BUILDING PERMIT

Permit Number 100522

is requesting permission to Build New 3 bedroom 2.5 bath single family home w/ rear garage

located at 5 TIDE MILL RD

CROSS SECTION A-A

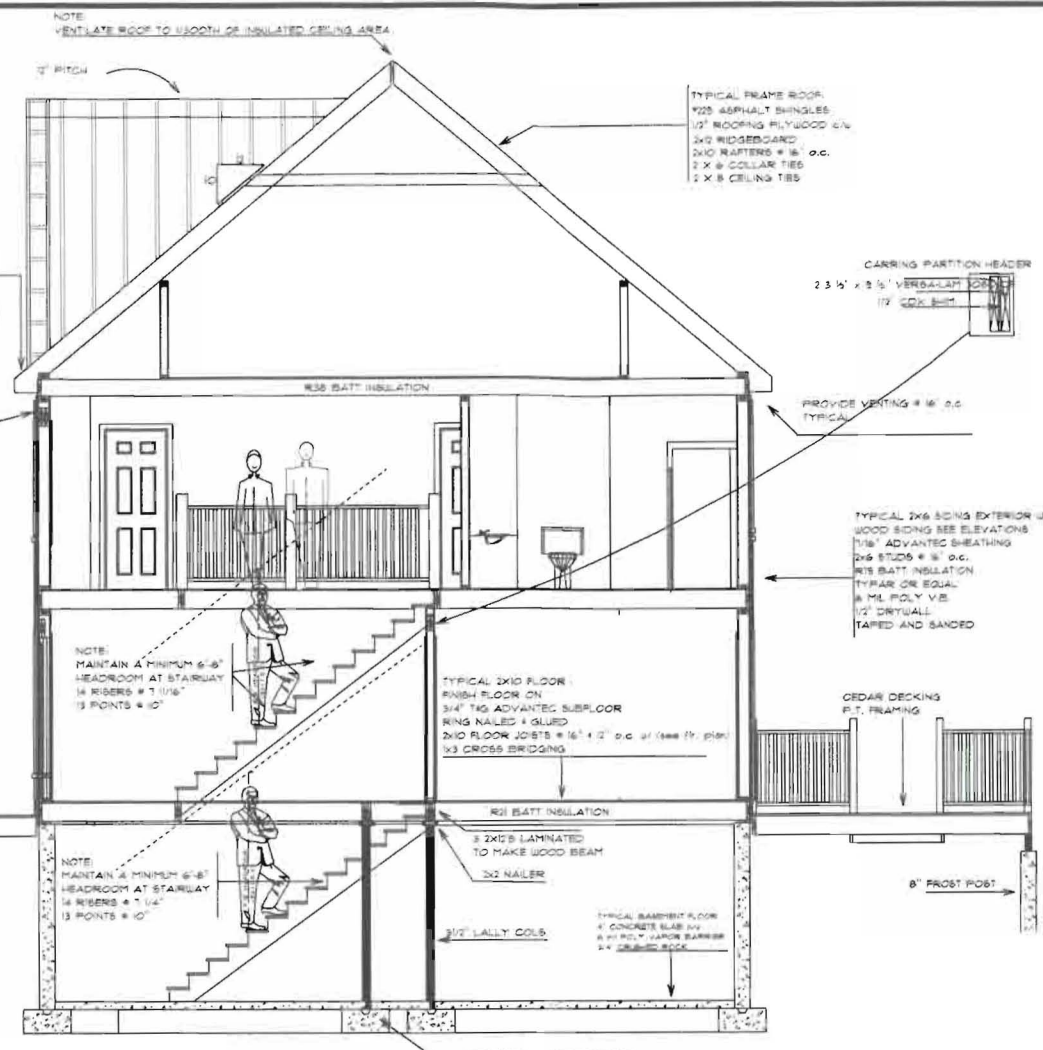
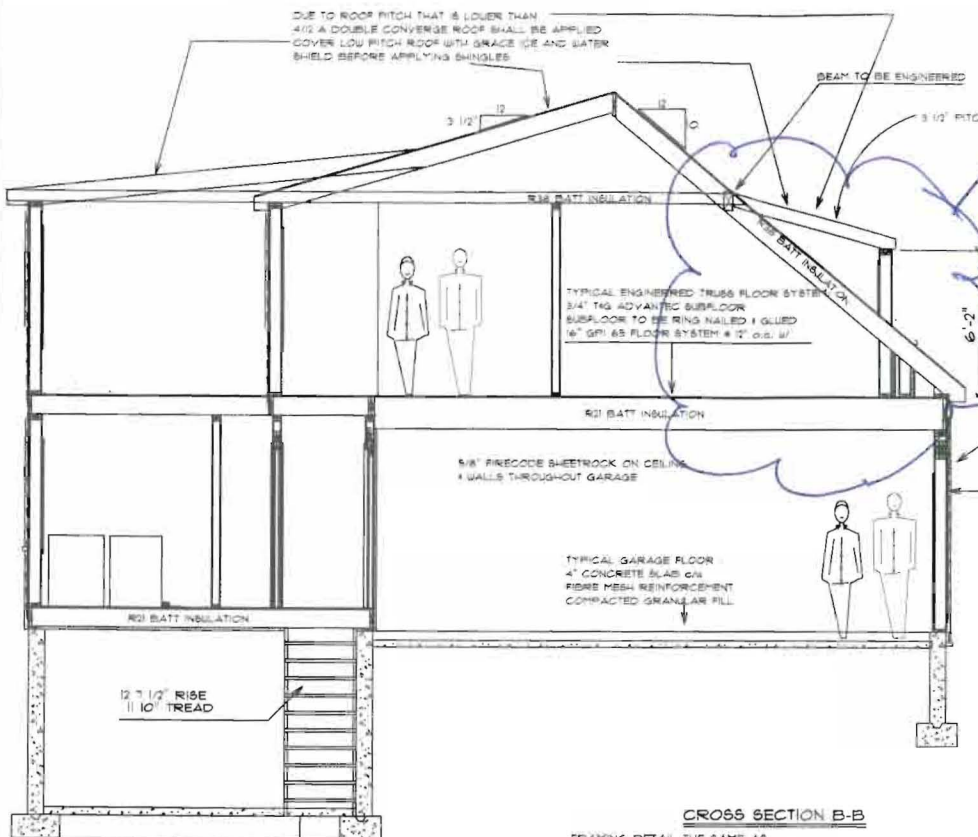
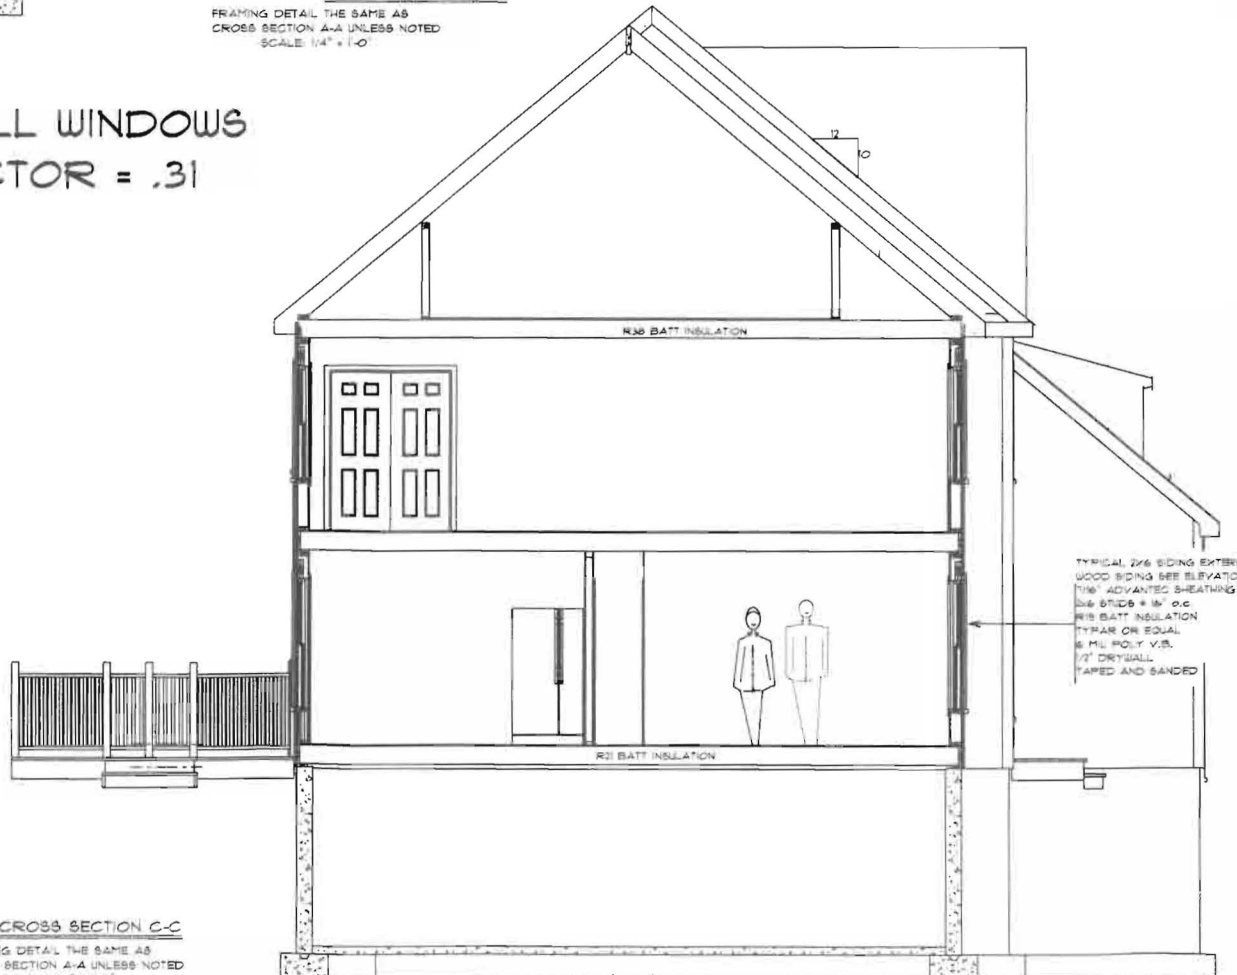
No Sections A-A, B-B, C-C 6/18 submitted

*350x55 Beam
3-2x10 BR*

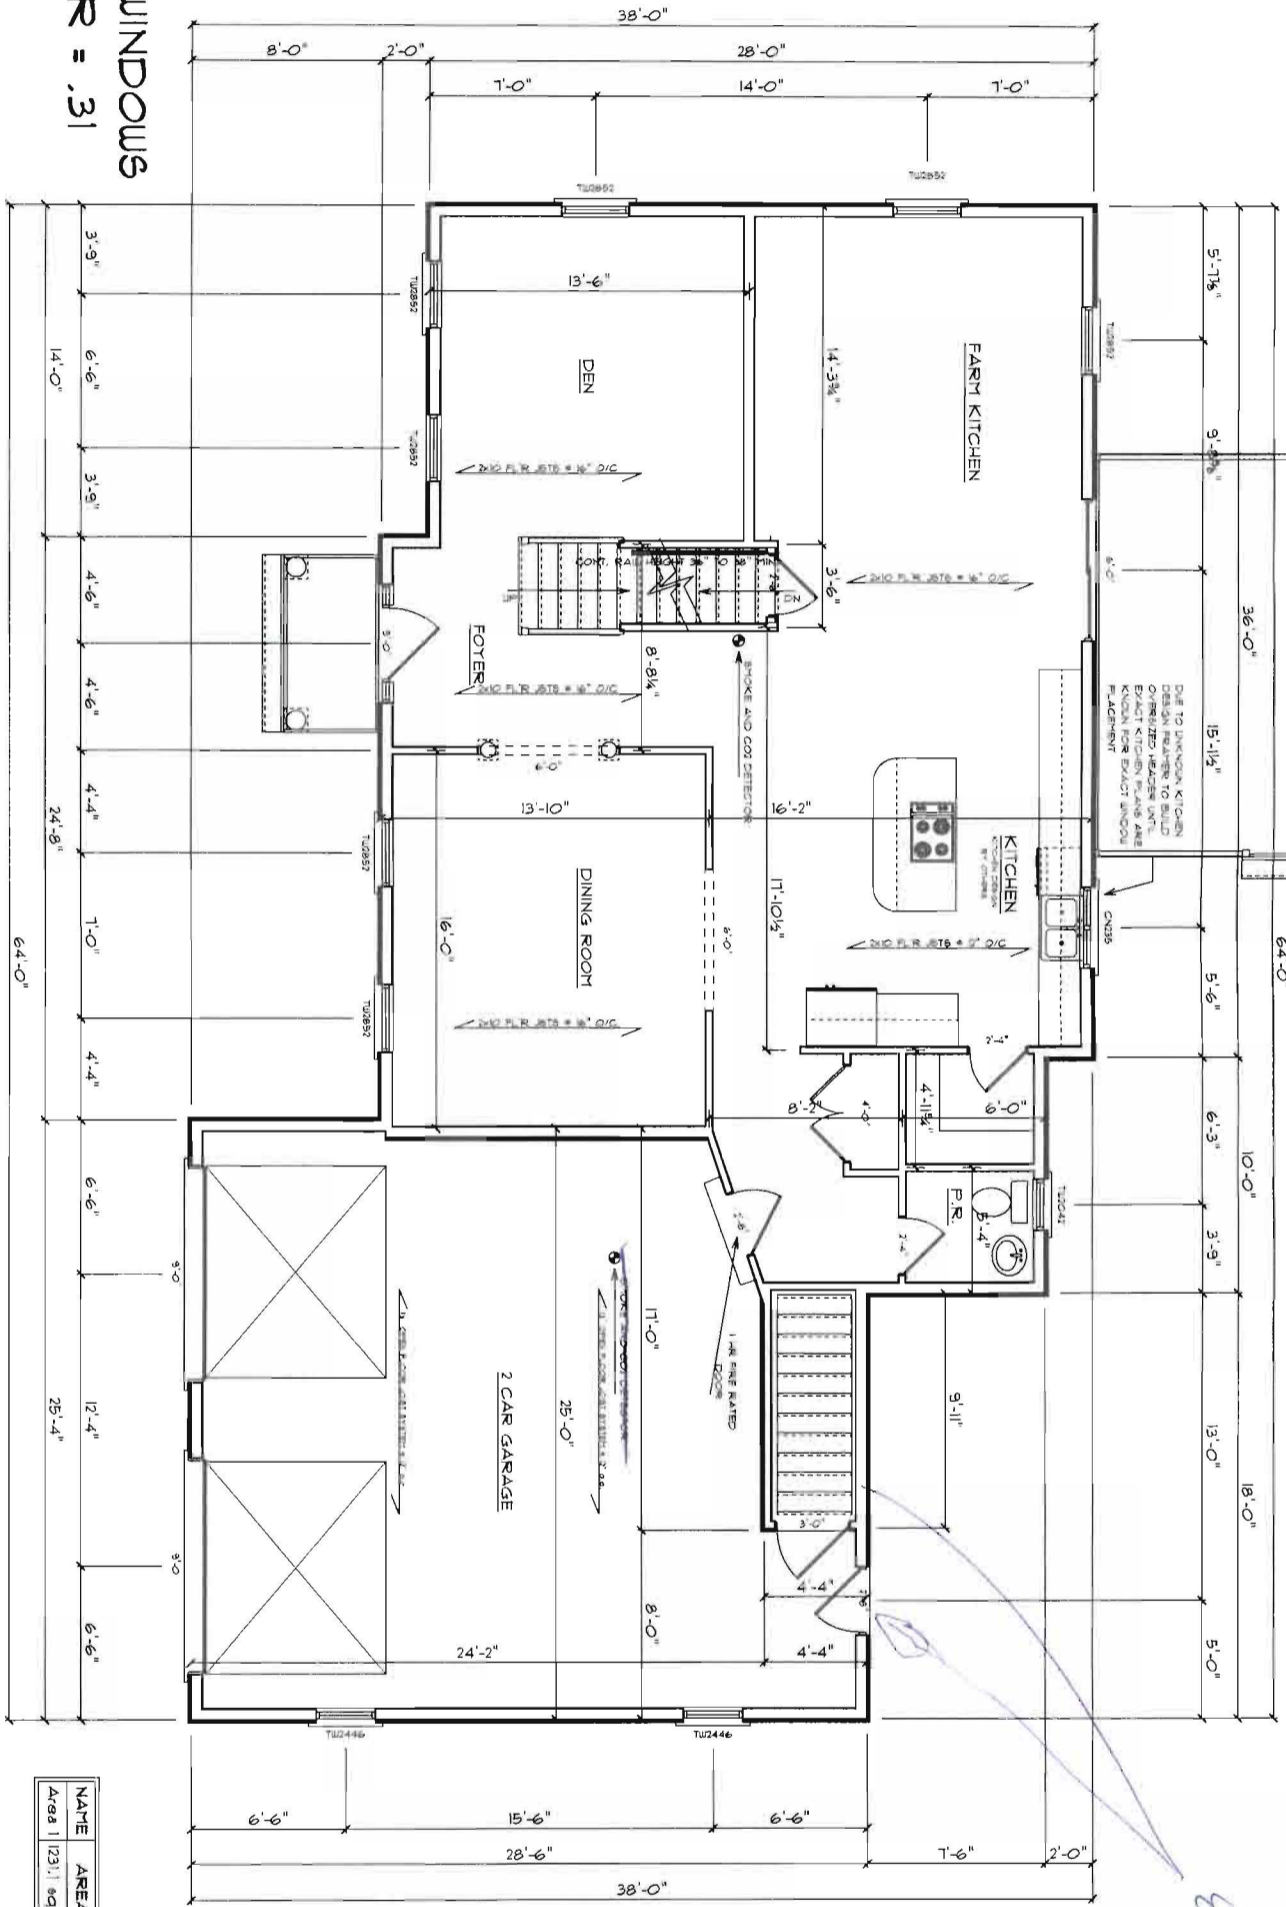
Second Floor Joist Species Dimensions and Spacing (Table R502.3.1(1) & Table R502.3.1(2))	Garage 13" OFJ 12" O.C. @ 25' House 2x10 @ 16" & 12" O.C.	→ per instructions → Need double @ load wall/dormer 6/24/10 - Changed direction of floor trusses or beam max 16'11" Condition for spec studs OK
Attic or additional Floor Joist Species Dimensions and Spacing (Table R802.4(1) and R802.4(2))	2x8 @ 16" O.C. + (2x6 @ 16" O.C. @ 26" Garage	scales 18'6" will reinforce w/ beam OR Angled ties OK

SCALE: 1/4" = 1'-0"
 FOUNDATION PLAN

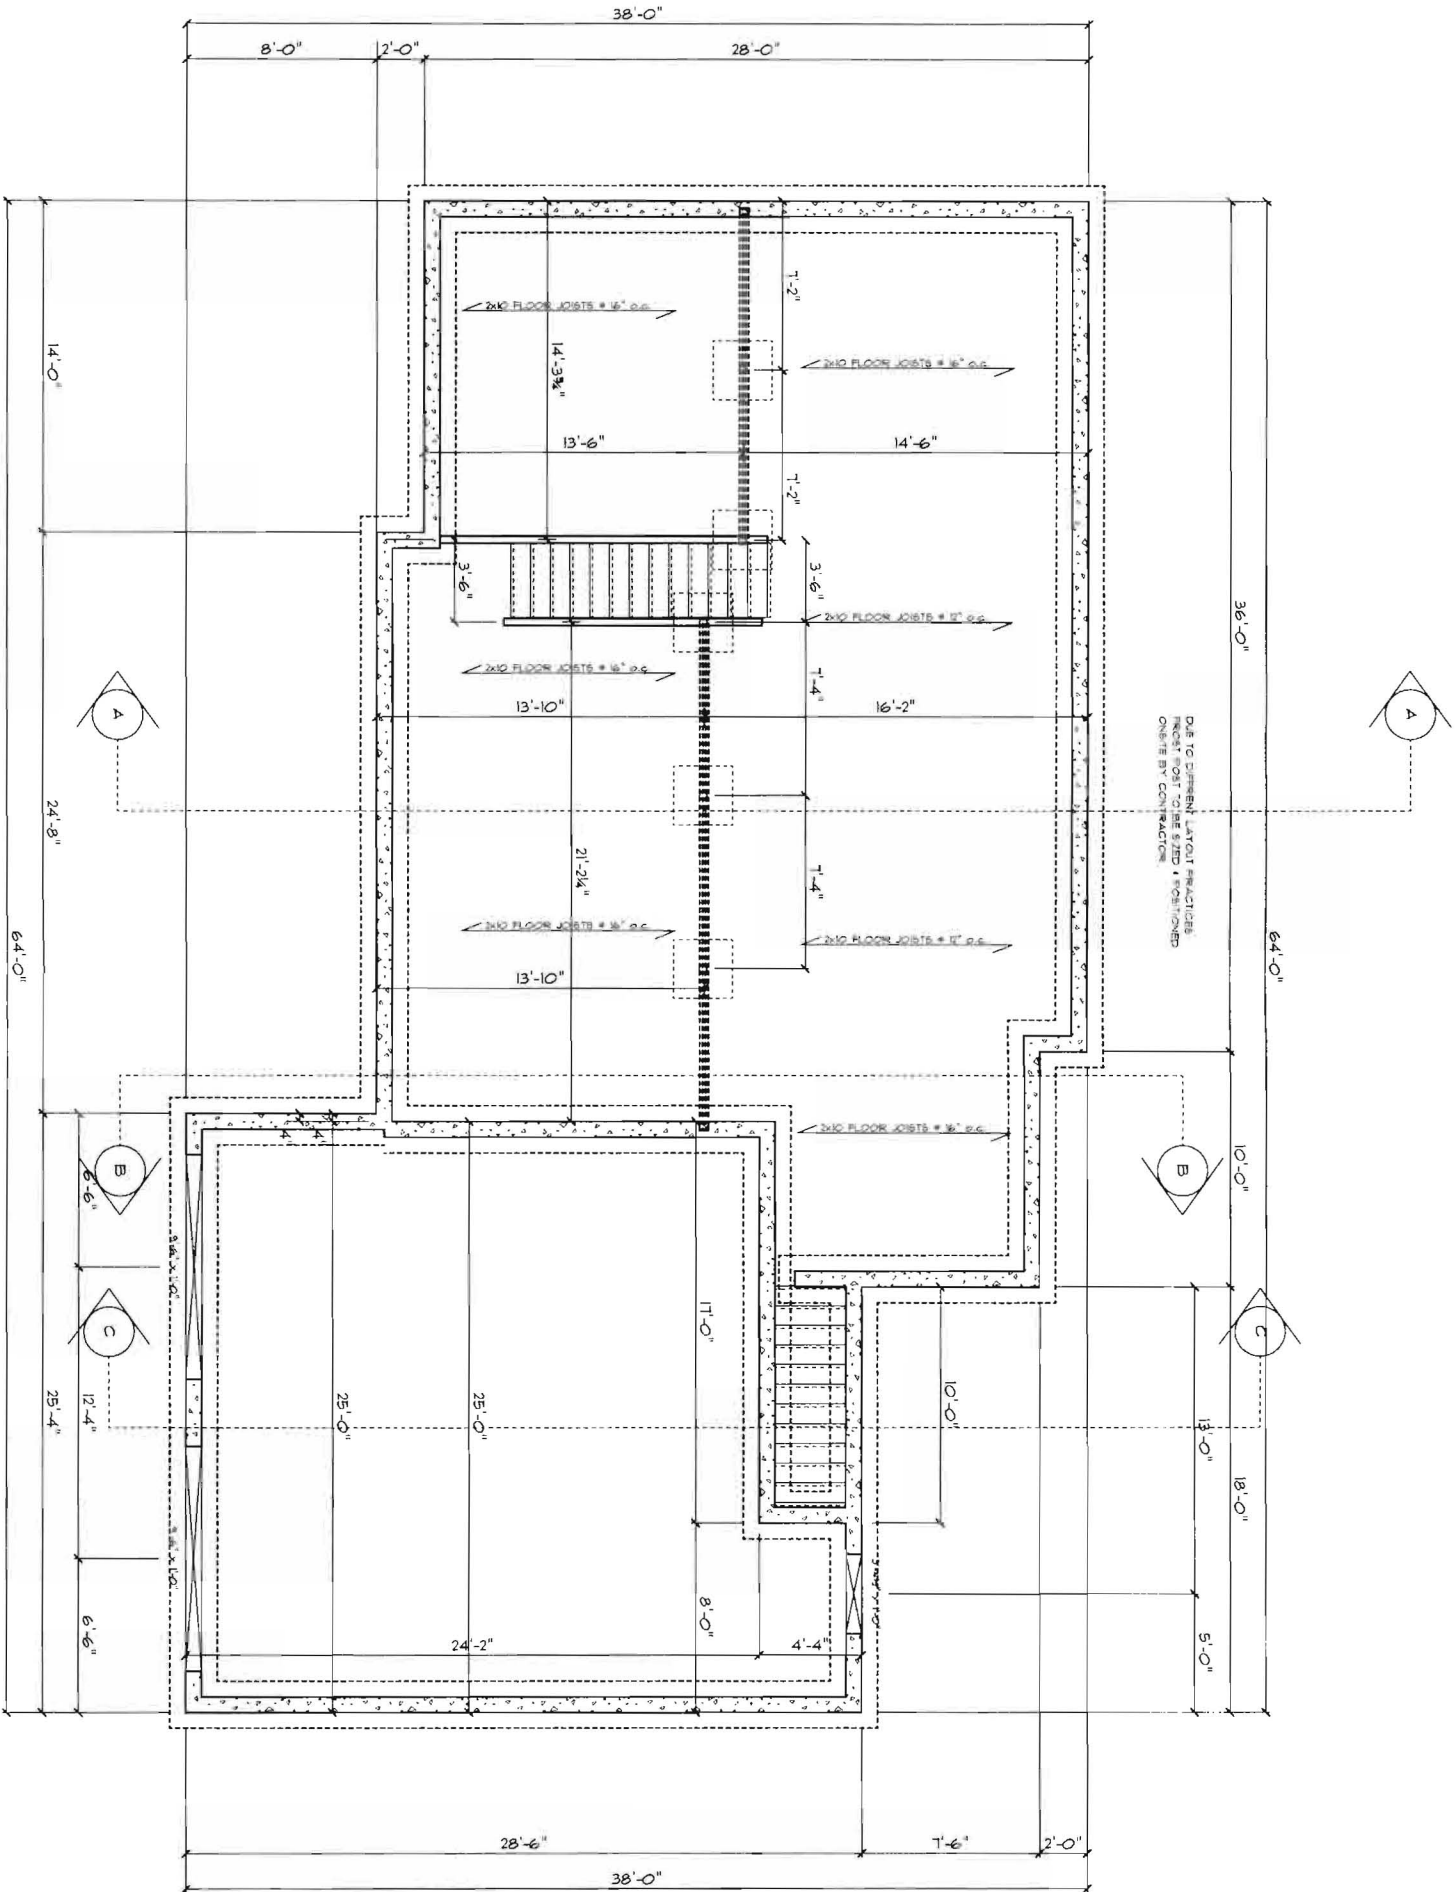
Type of Heating System	?	6/18 FFW Power vent	(8)
Means of Egress (Sec R311 & R312) Basement	yes stairs into garage not habitable		
Number of Stairways	2		
Interior	2		
Exterior	—		
Treads and Risers (Section R311.5.3)	R-7 ³ / ₄ " max 10" min tread		
Width (Section R311.5.1)	3'		
Headroom (Section R311.5.2)	? Main = 36"-38"	6/18 6'-8" &	(9)
Guardrails and Handrails (Section R312 & R311.5.6 - R311.5.6.3)			
Smoke Detectors (Section R313) Location and type/Interconnected	smokes & CO OK Also in garage →	per Rob T. Elect will delete	(10)
Draftstopping (Section R502.12) and Fireblocking (Section (R602.8)			
Dwelling Unit Separation (Section R317) and IBC - 2003 (Section 1207)	N/A		
Deck Construction (Section R502.2.1)	11.5 x 17 need Footing layout 2x10 @ 16" OC ? Beam	per Rob T. 3-2x10 beams 3 5000 tubes max span 9' OK	(11)
